Director, Transport Assessments Planning Services
Department of Planning, Industry and Environment
GPO Box 39
Sydney, NSW 2001

Application: SSI 7485

I write regarding the proposed modification to M4-M5 Link, Mod 2 The Crescent overpass and changes to pedestrian infrastructure in North Annandale, Rozelle and Rozelle Bay Foreshore area. *I object to the car overpass and the relocation of the GreenLink and I request*
I request RMS work with the community to explore alternate design options to the proposed new car overpass design and the changed pedestrian and cyclist links. I am seeking the reinstatement of the safe, direct access from the approved EIS GreenLink to create a continuous green open space connection from the Rozelle Rail yards and Annandale to the foreshore. The GreenLink was more than just a walk way - it put people central to the design, maximising safety, and providing much needed accessible open space for the community now and into the future Bays Precinct design.

Figure 4-2 Pedestrian and cyclist bridge infrastructure options

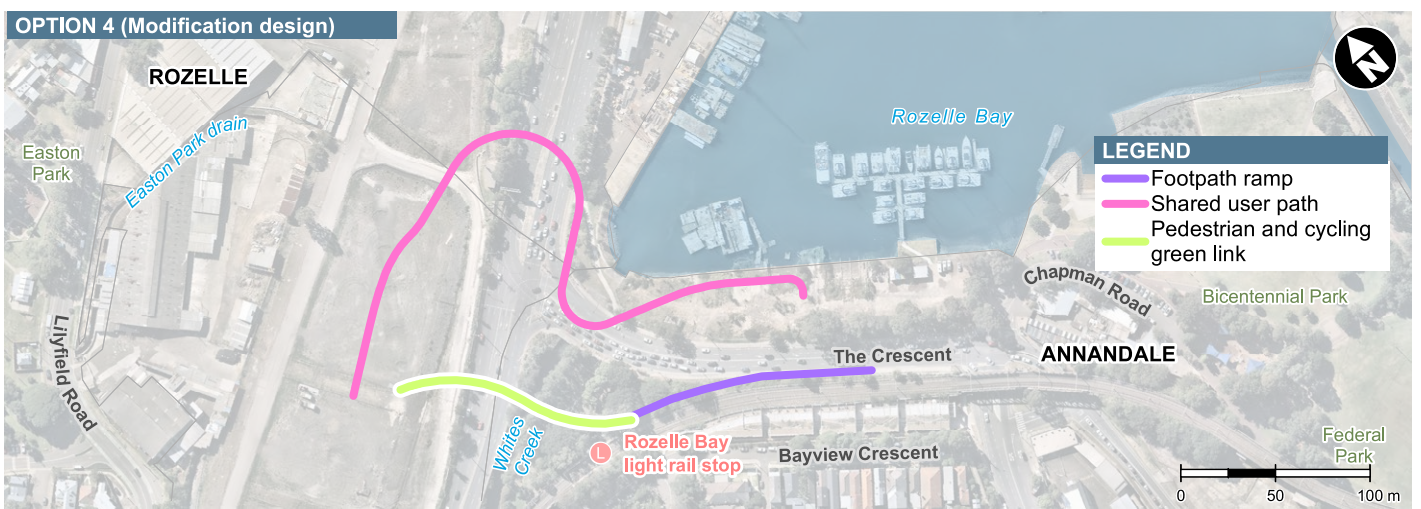
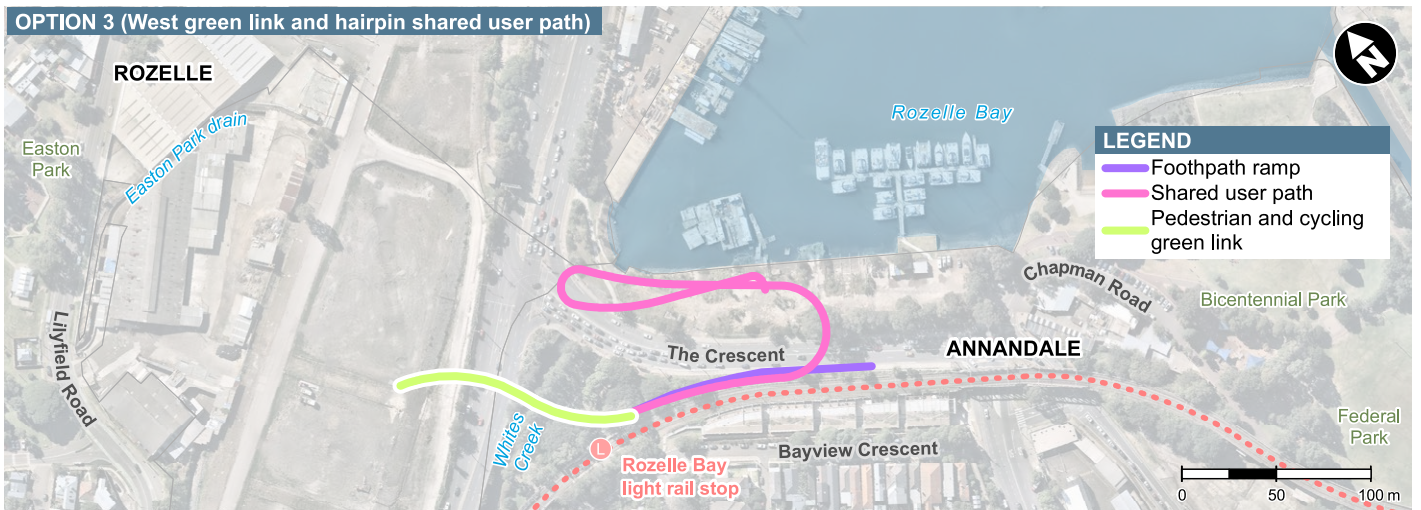
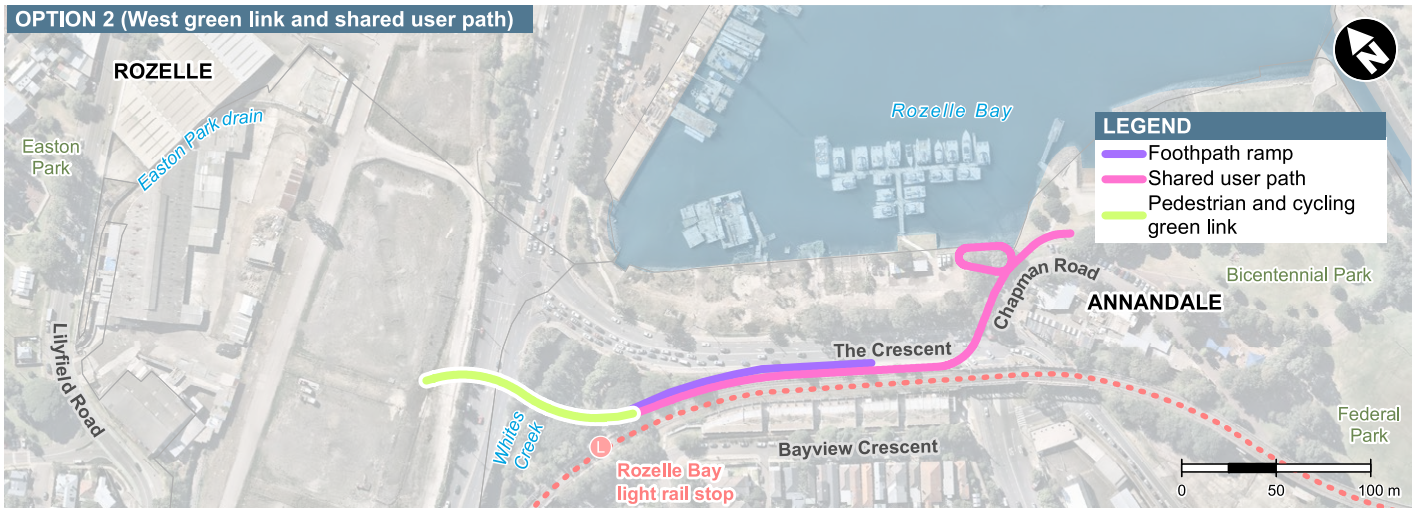
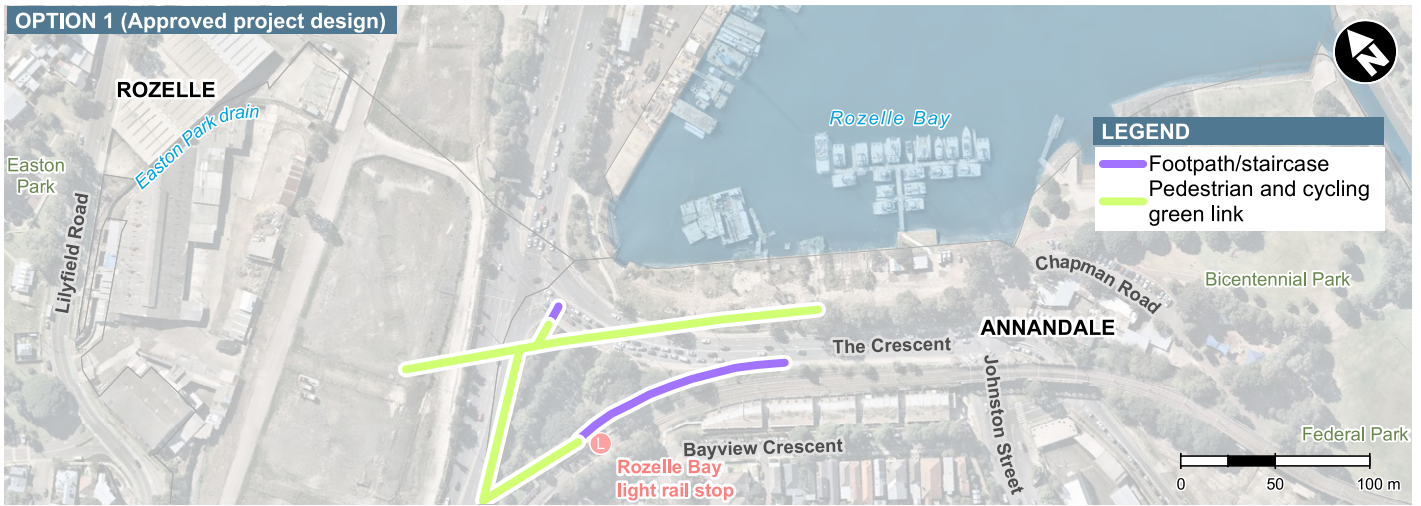
The overpass has significant visual and urban impacts. It has forced the relocation of the green bridge west of The Crescent requiring a pedestrian crossing of four traffic lights.

It has added another elevated pedestrian crossing from the same starting point in the new Goods yard parklands. This crossing is longer than it needs to be due to extra height required to get over the new vehicle overpass. These changes have greatly added to the visual impact and clutter.

- **Reinstate the GreenLink connecting communities and green open space from Rozelle to Bicentennial Park**

Figure 4-3 The Crescent, Johnston Street, Chapman Road intersection options

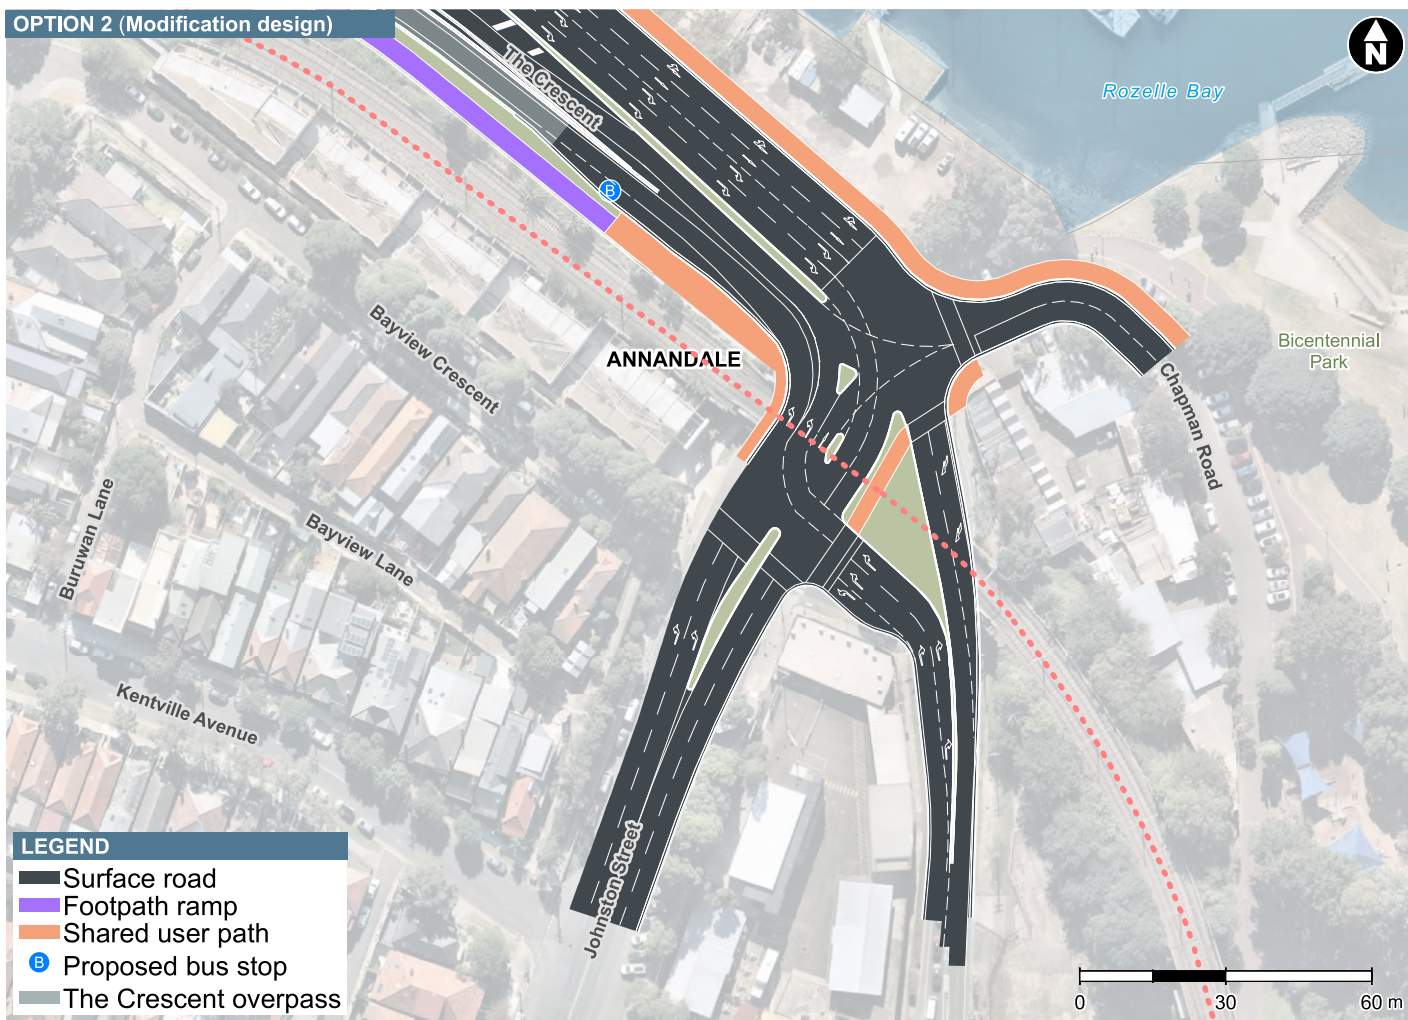
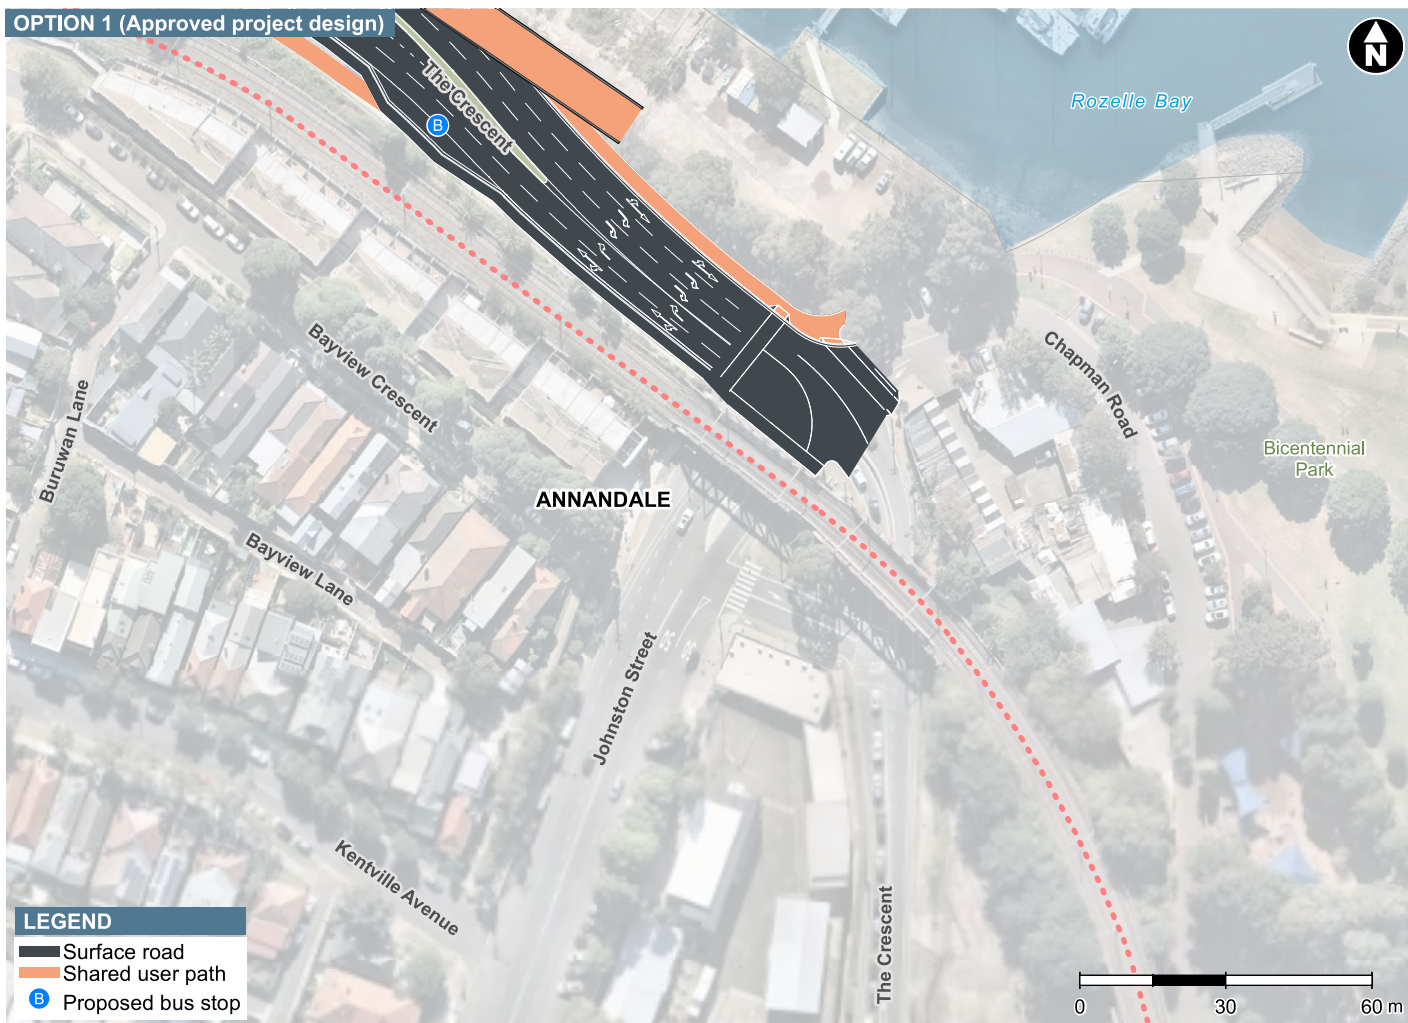
The proposal bottlenecks the majority of vehicle movements turning right to Victoria Road and the Anzac bridge from three lanes down to one lane with likely traffic impacts up Johnston street and The Crescent.

It doesn't allow a right hand turn into James Craig road.' From The Crescent heading city bound.

Return the Johnston Street / The Crescent pedestrian crossing to a single traffic light as per the current situation, and location.

Figure 4-4 Elevation: Indicative view of The Crescent overpass

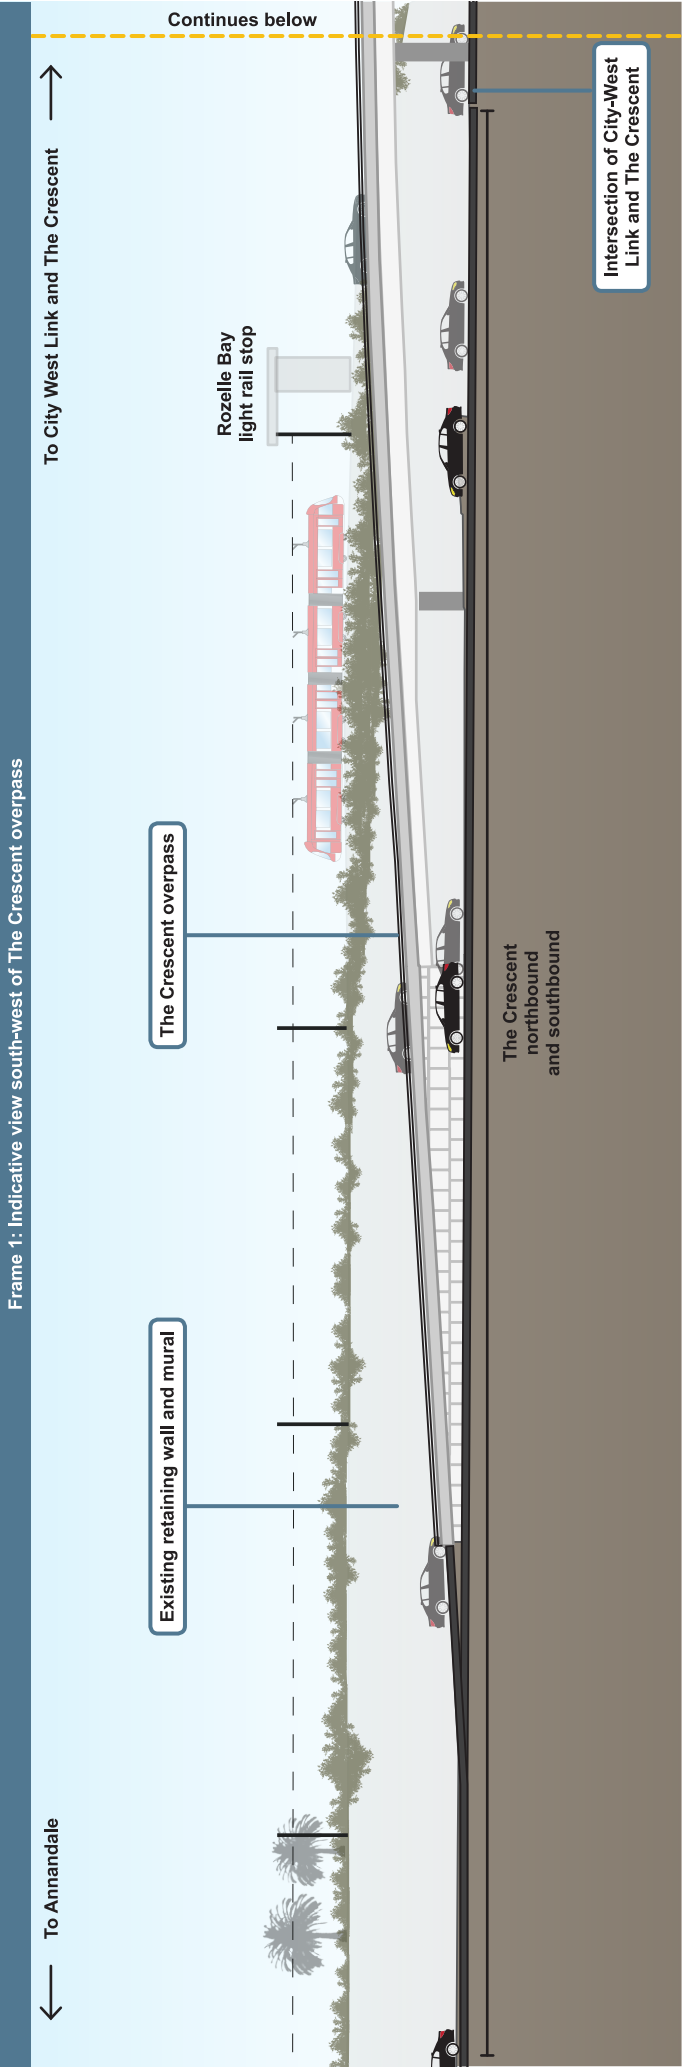
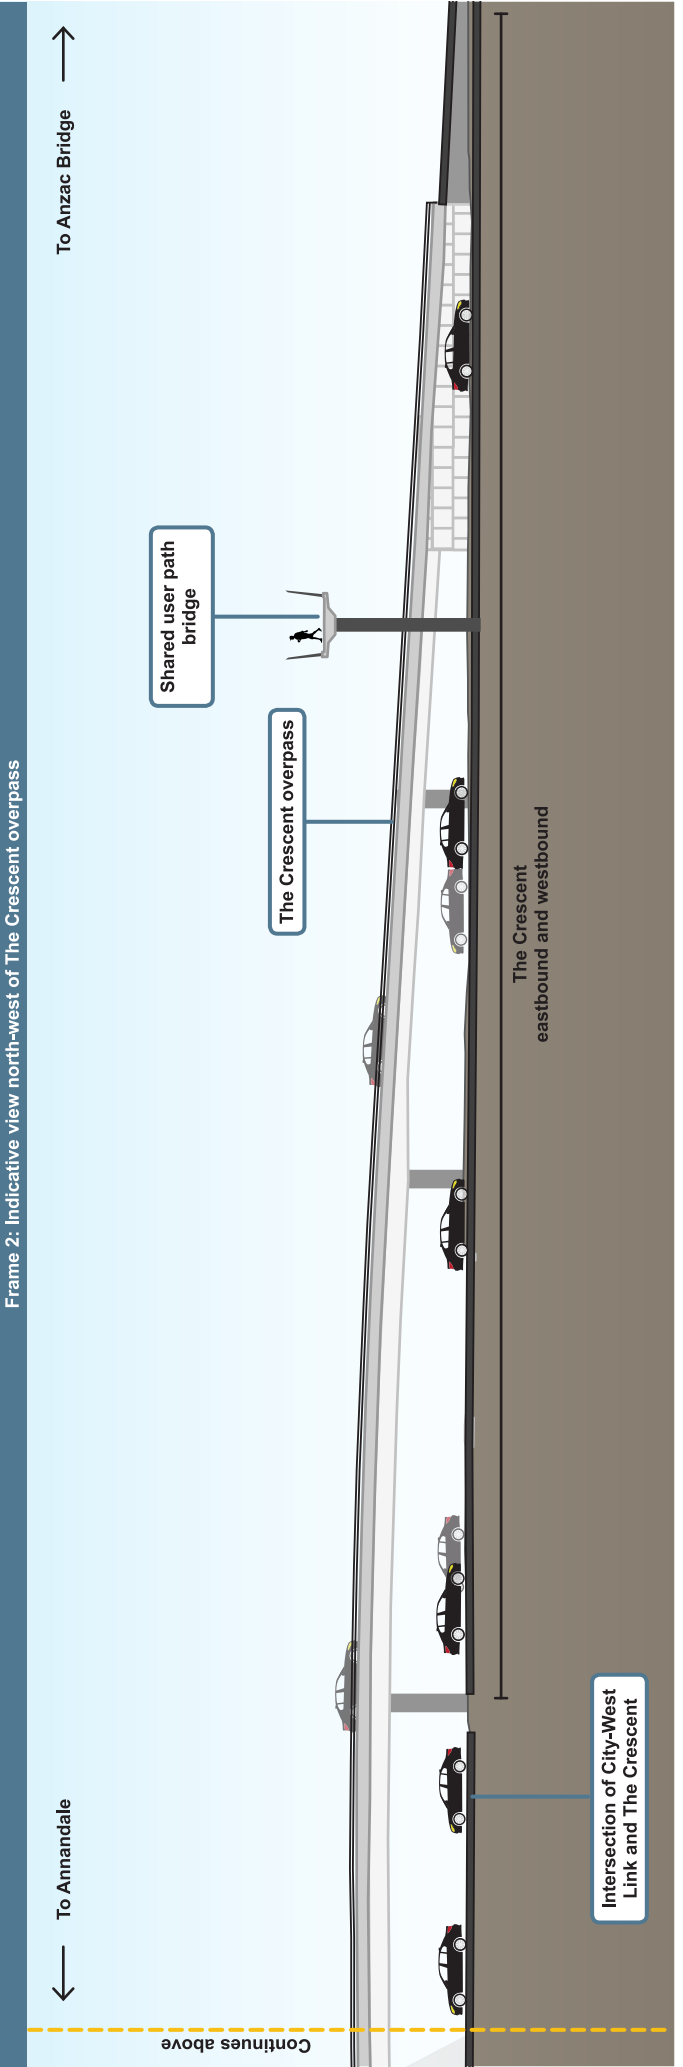
- **Remove the overpass.**

We object to the proposed overpass option. It has limited improvements to

vehicle waiting time, but these are outweighed by significant visual and pedestrian connectivity impacts.

It blocks views of the water from the relocated green bridge.

The overpass should be replaced with an at grade intersection as per the EIS or a short 120m tunnel option with a single land bridge option.

Change the overpass to a short (less than 120m) tunnel under the city West link with slot trench approaches rather than the proposed overpass. This underpass needs to be designed to also facilitate the single pedestrian crossing at Johnston's Street. An underpass provides the best visual and urban outcomes. It allows the retention of the green bridge in a location to best connect the parklands together.
